COUNTY COUNCIL'S RESPONSE TO CONSULTATION ON THE FOLLOWING DEVELOPMENT PROPOSAL

Application No: 20/02446/F

Proposal: Formation of inland waterways marina with ancillary facilities building, car parking, access and associated landscaping including the construction of a new lake - re-submission of 18/00904/F

Location: Glebe Farm, Boddington Road, Claydon, Banbury

PROPOSED BRIDGE CROSS SECTION - SCALE 1:50

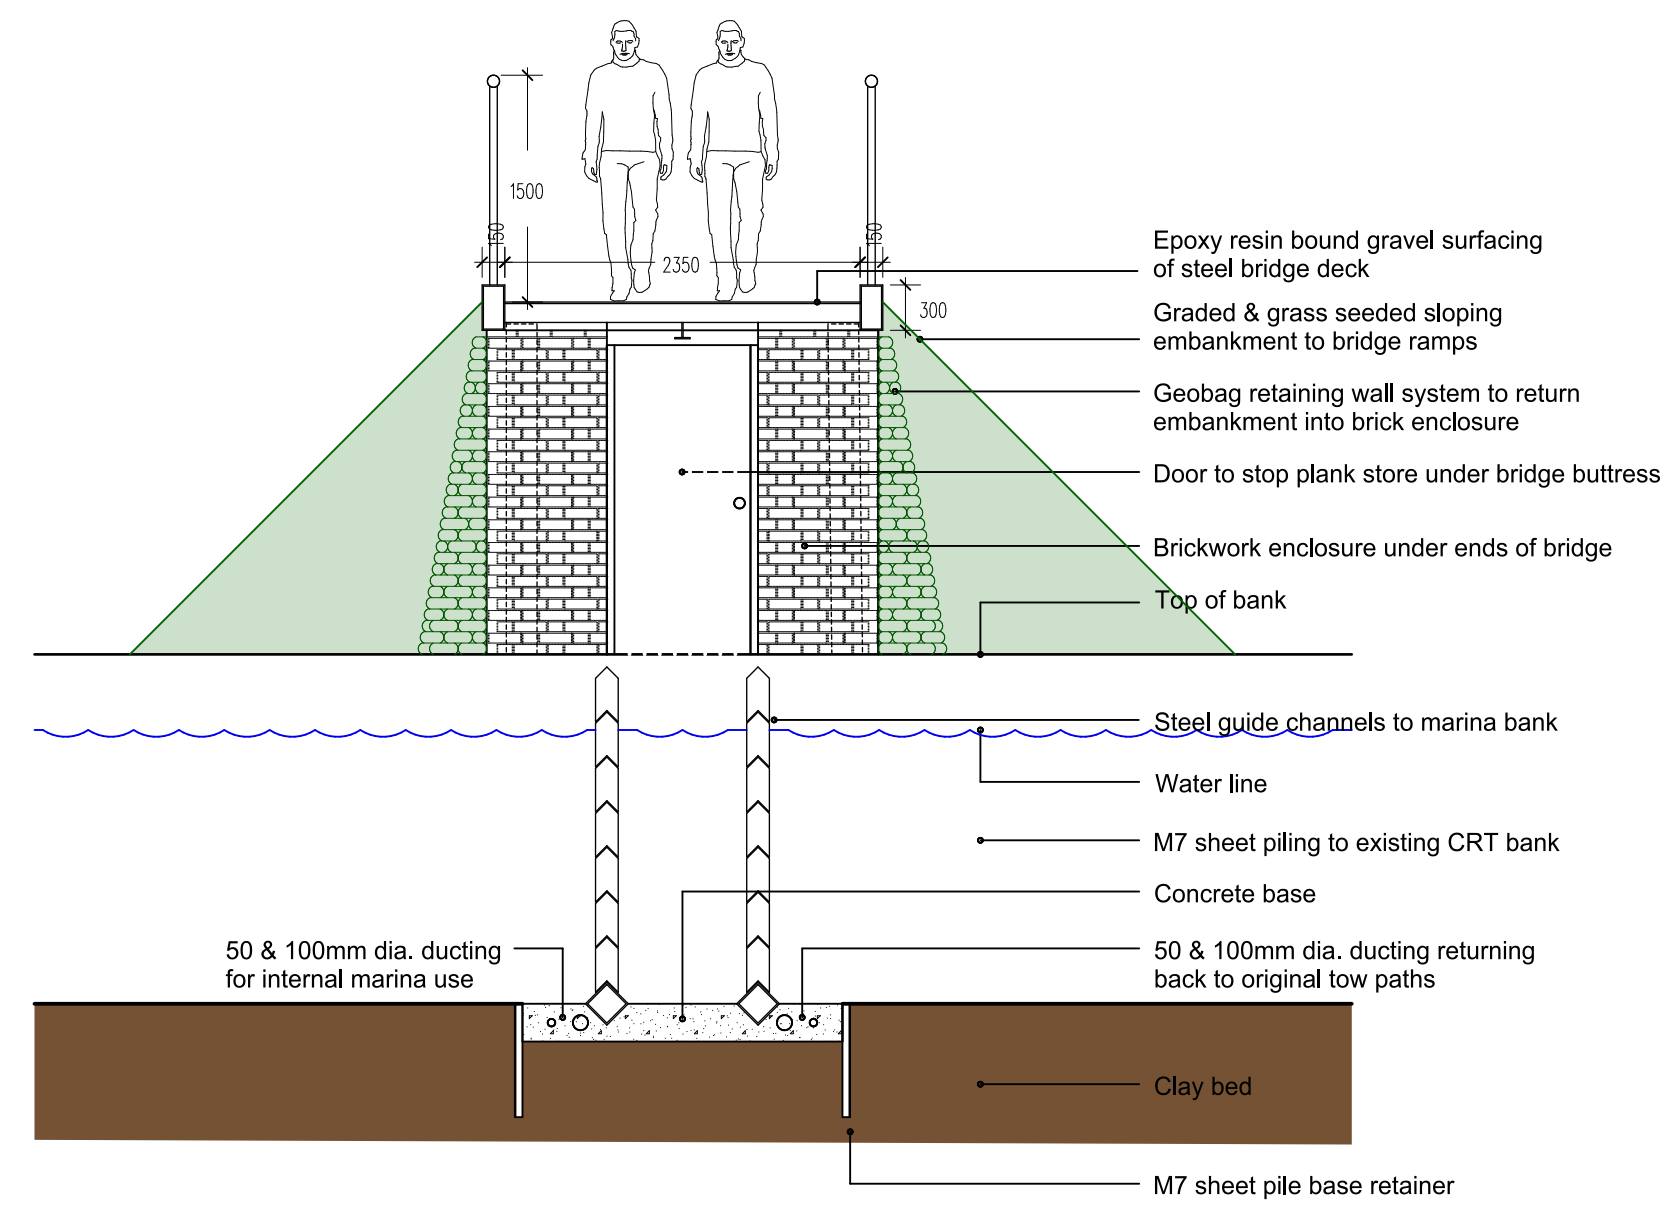
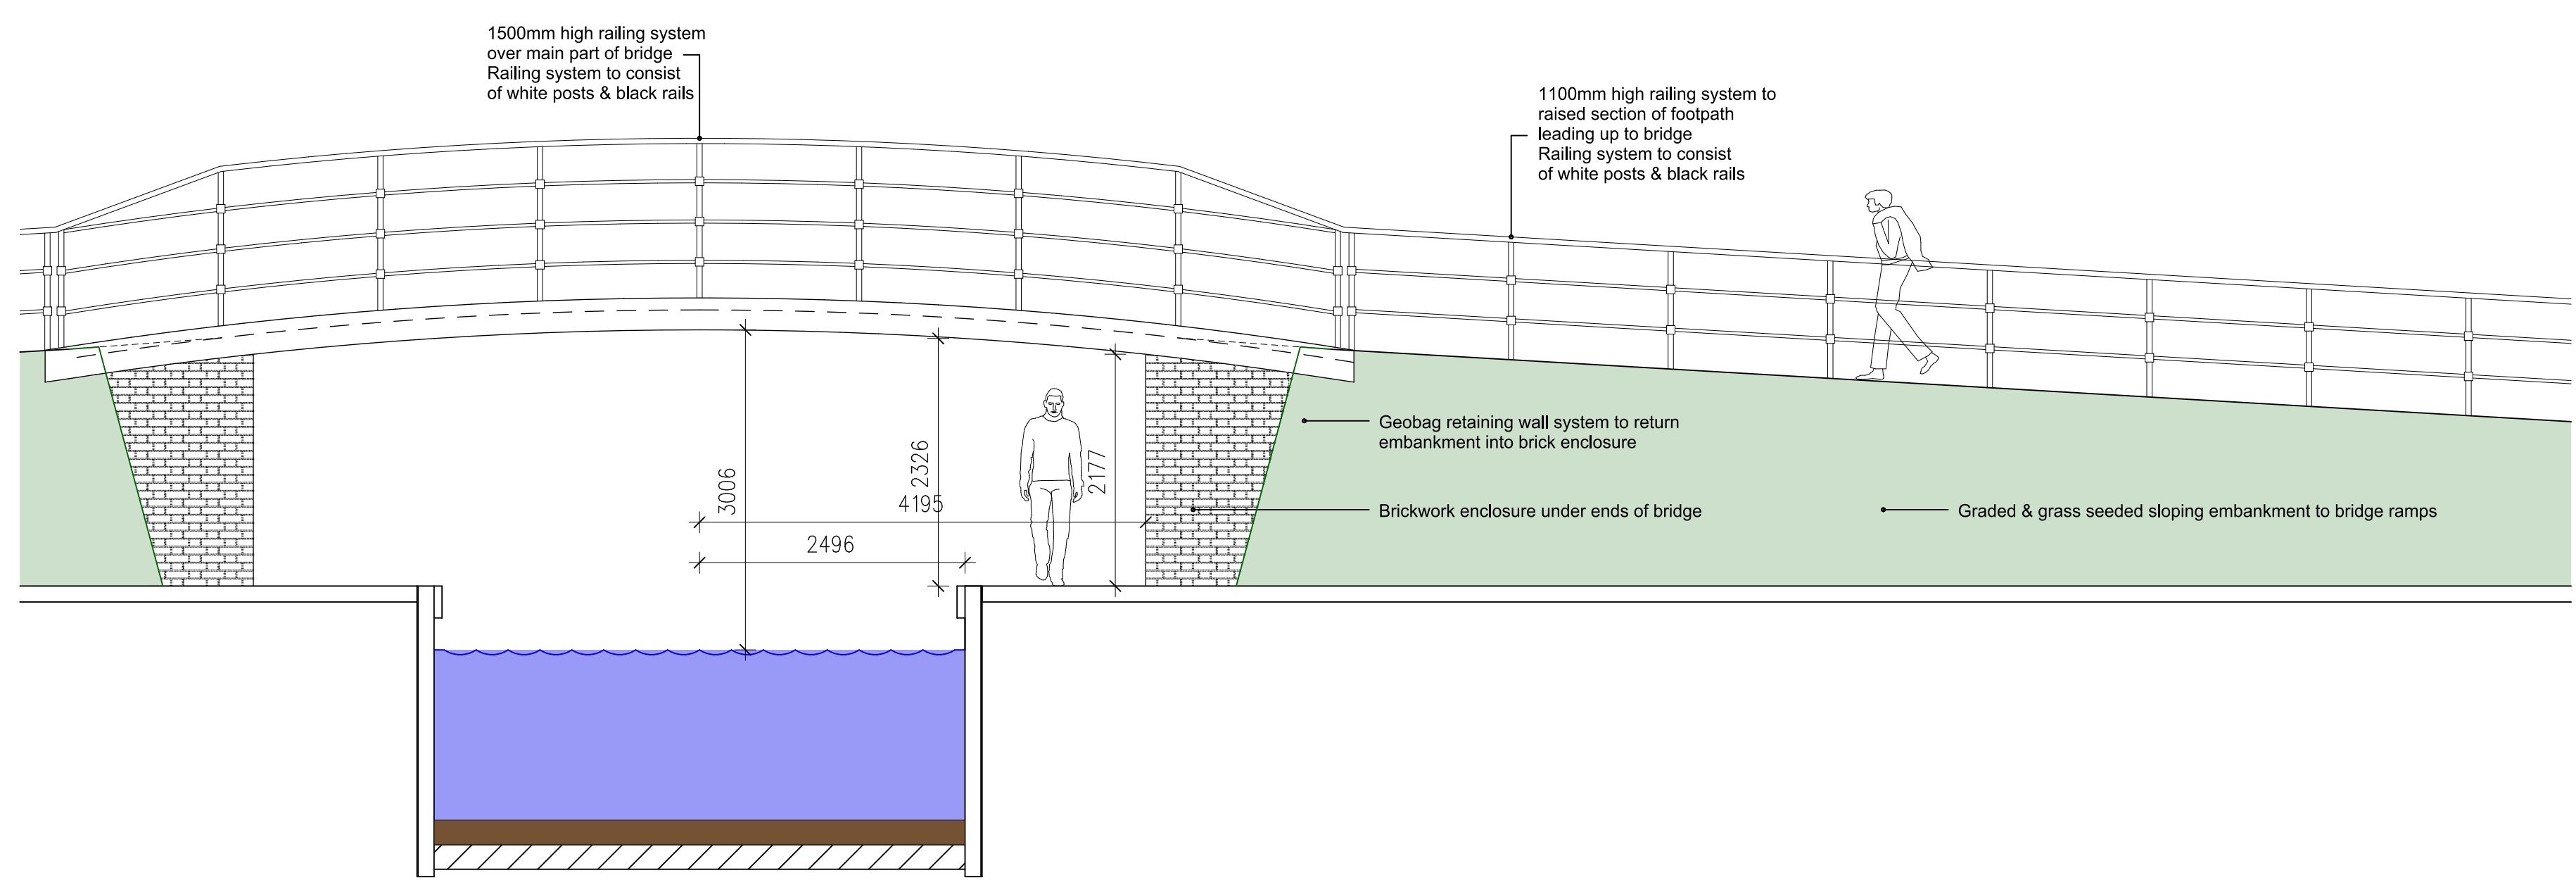
The proposed footbridge should be constructed to DMRB standards, or to Canal and River Trust (C&RT) public towpath standard. This structure must be maintainable by the applicant or C&RT and OCC accepts no liability for its construction, public liability or future maintenance. The footpath/towpath will need to be closed to enable construction and a temporary closure needs to be applied for from OCC. Note that there is normally a 12 week lead time for this. It is expected that the footpath/towpath will be protected from plant damage and repaired to same or higher standard after the works have been completed.
